### **Final Report - Corrections Required** **Application No. ANEX-24-0003**

**Description : Matrix Design Group on behalf of Colorado Springs Equities LLC is submitting a serial annexation petition for seven parcels and Land Use Plan/Rezoning exhibit for a portion of the subdivision known as Rock Creek Mesa.**

**Document Filename : 224.023-LEGAL-RCM ANNEX 3.pdf**

ANNEXATION PLAT
ROCK CREEK MESA ADDITION NO. 3

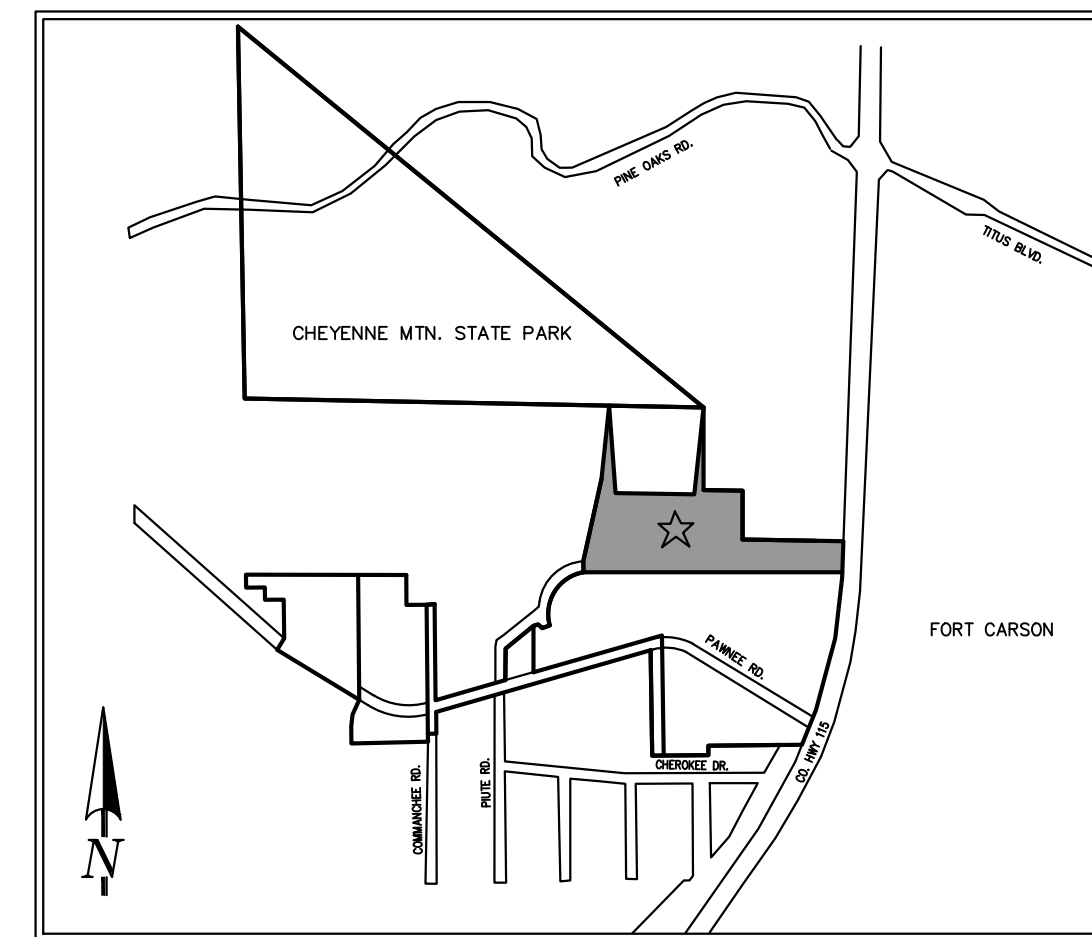
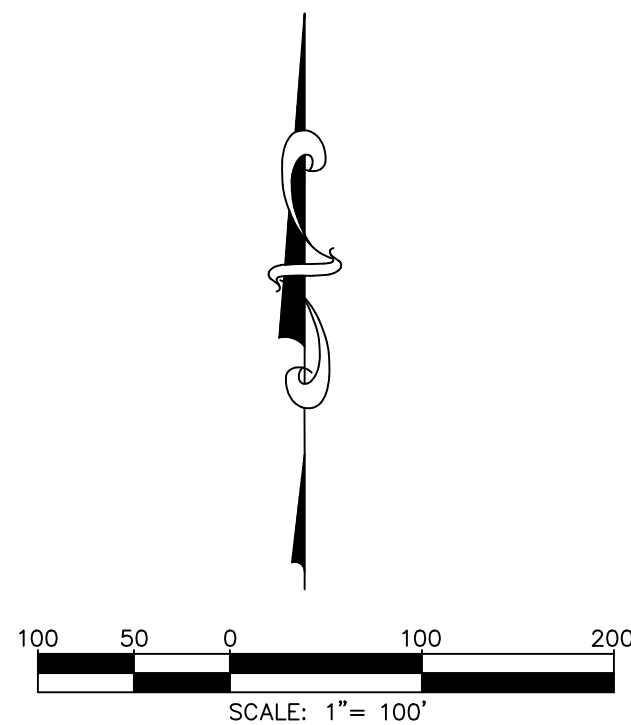
<b>Comment ID</b>	<b>Page Reference</b>	<b>Reviewer : Department</b>	<b>Review Comments</b>
14	1	Gabe Sevigny : Planning	Any updates to the annexation plat should also be updated here and vice versa
15	1	Gabe Sevigny : Planning	Add ANEX-24-0003
32	1	Cory Sharp : Planning	Please revise exhibit A to: Rock Creek Mesa Addition No. 3
33	1	Cory Sharp : Planning	Please add the area at the end of the legal description

Please revise exhibit A to:  
Rock Creek Mesa Addition  
No. 3

Please add the area at the end of the legal description

Add ANEX-24-0003
